Proposed rear extension & dormer to side (this application lies within the South Downs National Park Authority)

Glenthorne Findon Road Findon

Thank you for your internet representation made on 13th February 2012 which has been recorded as an **objection** with the comments as follows:

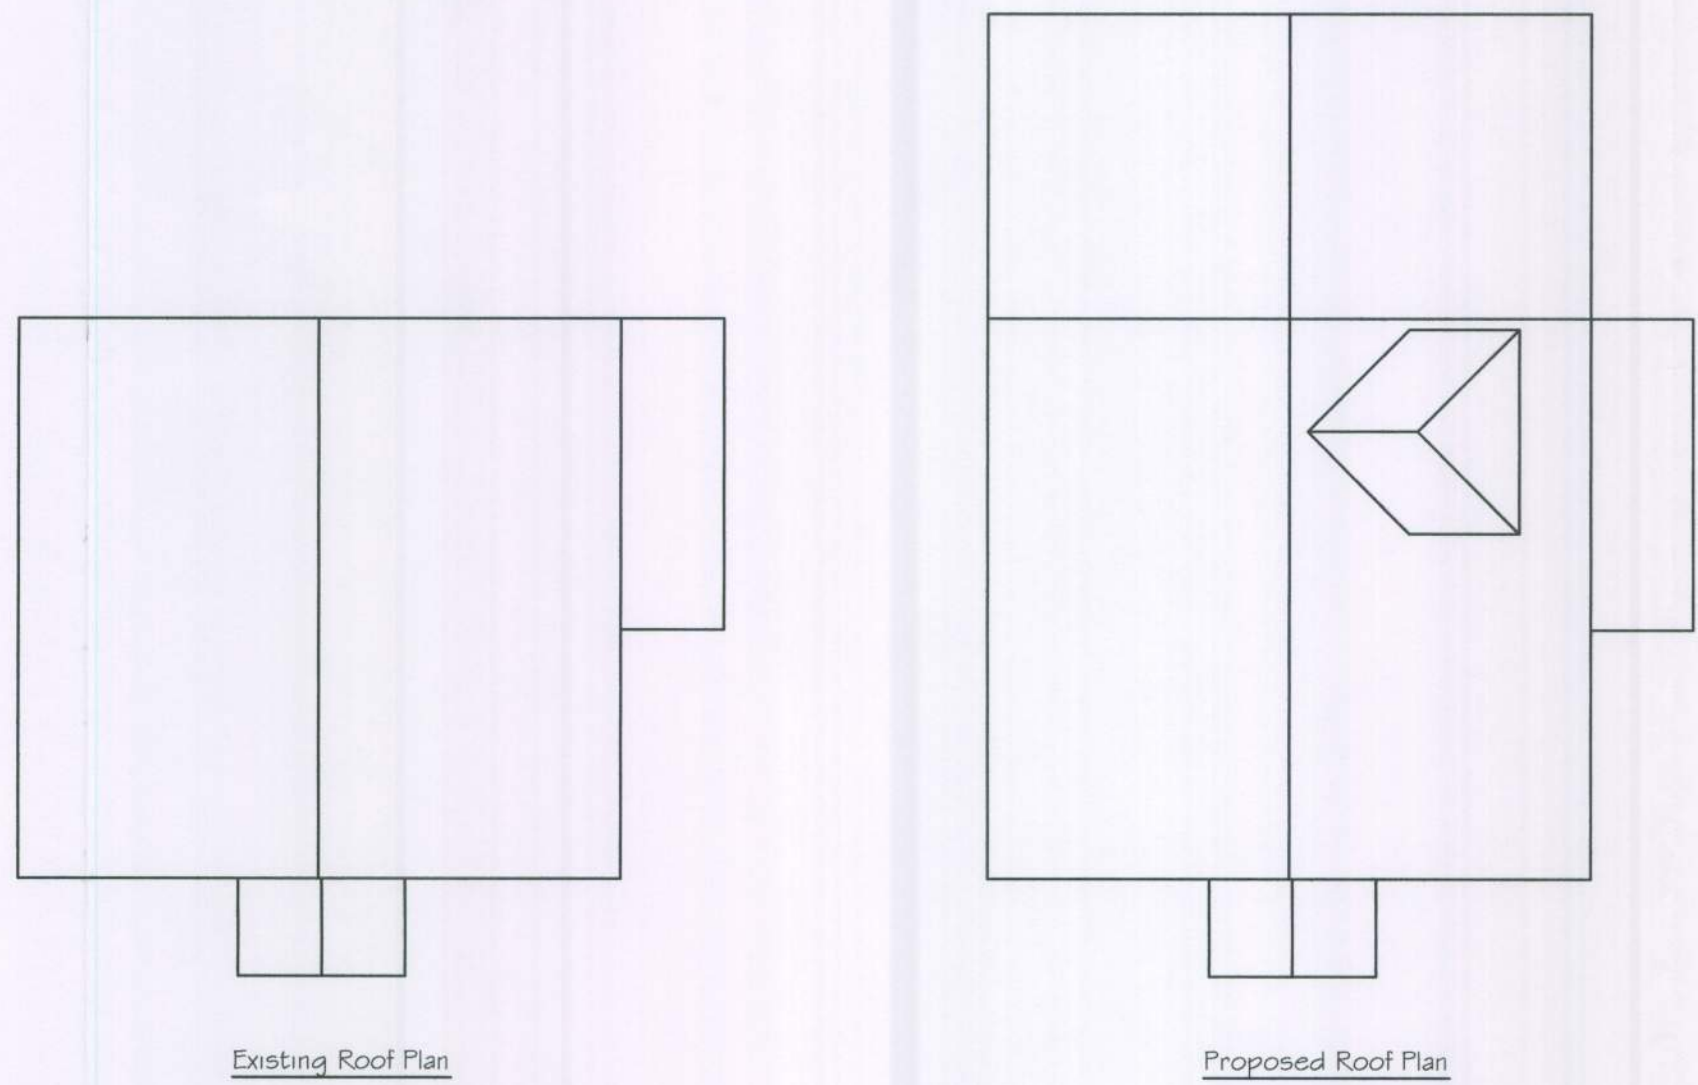
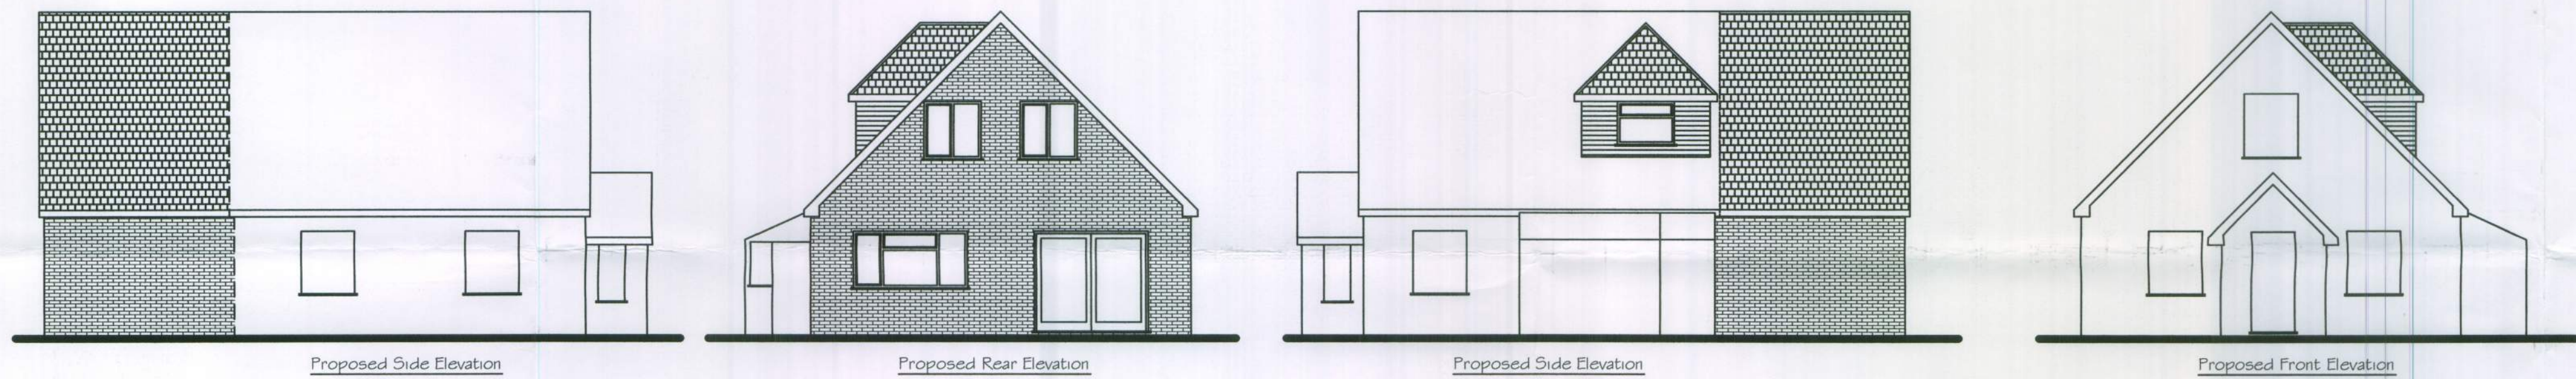
I live next door to this property and am concerned to learn this is a double story extension with dormer window - my concerns are the extension will block out my natural light to the rear of my property and the dormer window will overlook my property therefore invade my privacy. □
